Rezoning Transportation Analysis

Petition Number: 2020-074

General Location Identifier: Tax ID 05107104

SHEET TITLE:
CONDITIONAL REZONING: CONCEPTUAL SITE PLAN
SHEET NUMBER:
RZ1.0

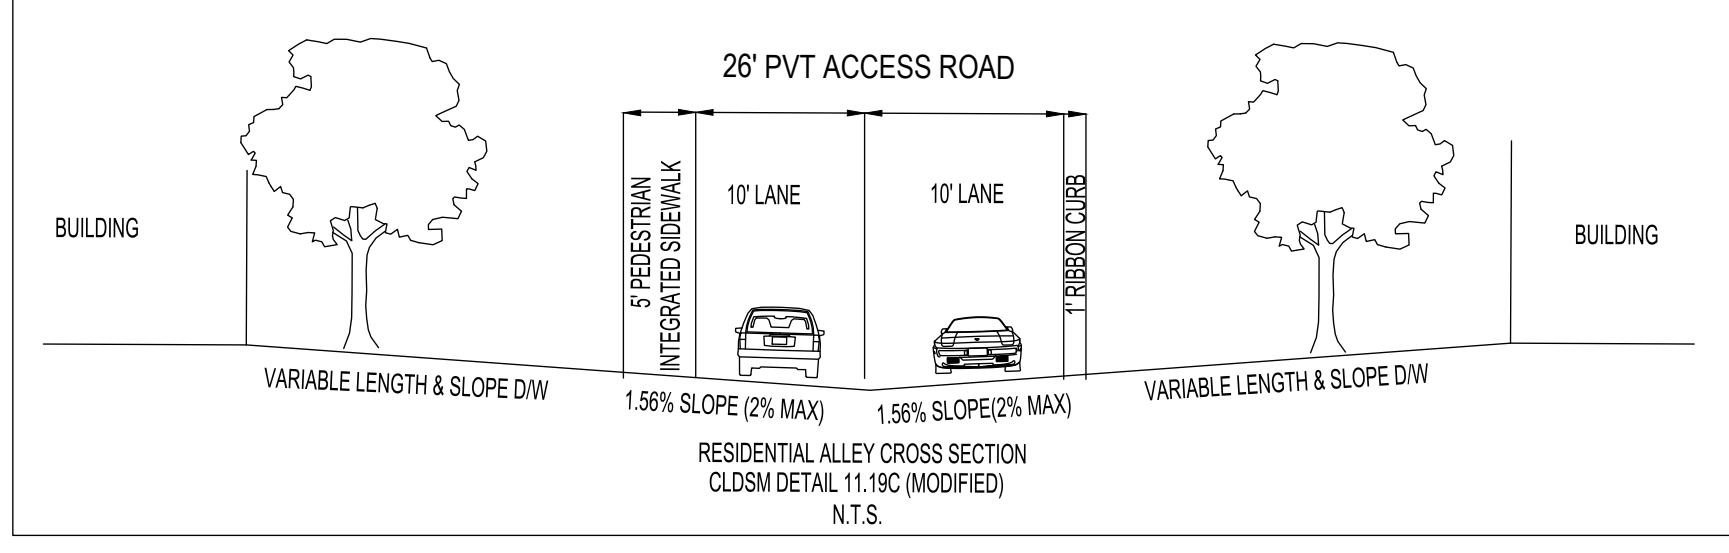
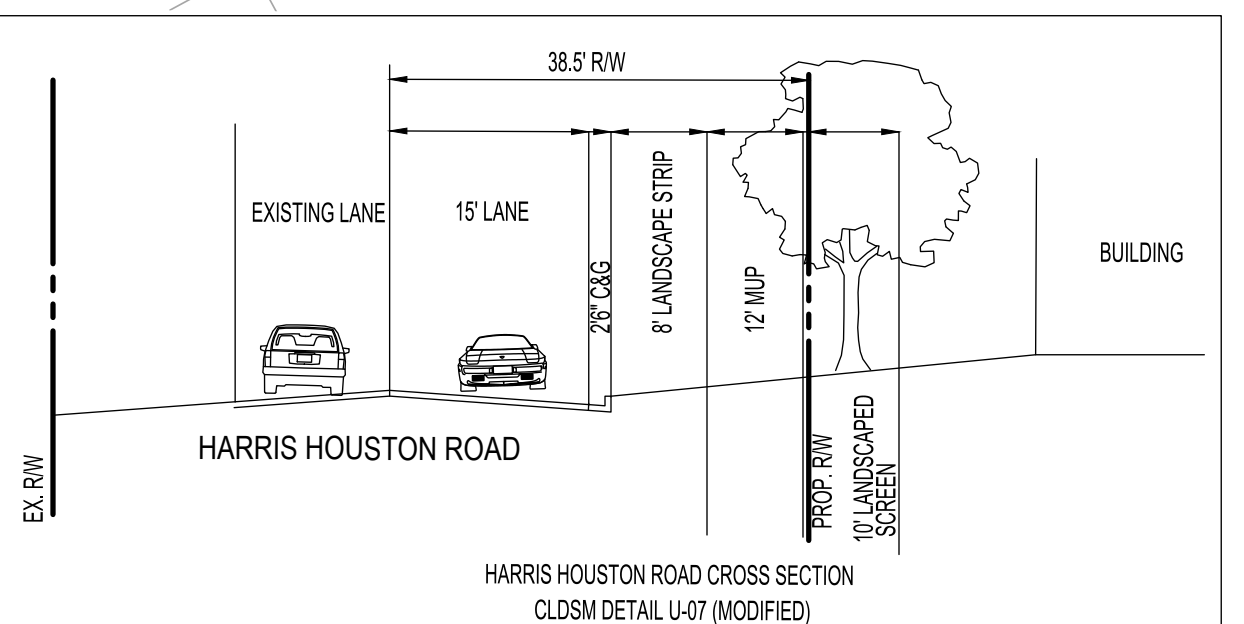
1. **Curbline** The proposed zoning district has a setback measured from back of the existing or proposed future curbline.
 - a. **Harris Houston Road:** Location of curb and gutter should be placed 22.5-feet from road centerline, in reference to CLDSM std. USDG-07 Local Collector Street, with the modification of adding an additional 5-feet of pavement for an on-street bike lane.

The site plan should show the curb and gutter labeled and dimensioned from the centerline for each road.
2. **Traffic Study** A Traffic Impact Study is not necessary for the complete review of this petition due to the site generation more than 2500 daily trips. If the during the permitting process the site generates more than 2500 daily trips, then a traffic study will be required.

3. The petitioner should revise the site plan and conditional note(s) to label and dimension the proposed right-of-way to be dedicated from the road centerline. CDOT requests right of way set at 2' behind back of sidewalk where feasible.

4. The petitioner should revise the site plan to add a note specifying dedication and fee simple conveyance of all rights of way to the City before the site's first building certificate of occupancy is issued. CDOT requests right of way set at 2' behind back of sidewalk where feasible.

5. The petitioner should revise the site plan to add a note specifying all transportation improvements will be approved and constructed before the site's first building certificate of occupancy is issued. The petitioner may phase transportation improvements if said improvements and phasing are explicitly described in site plan notes.
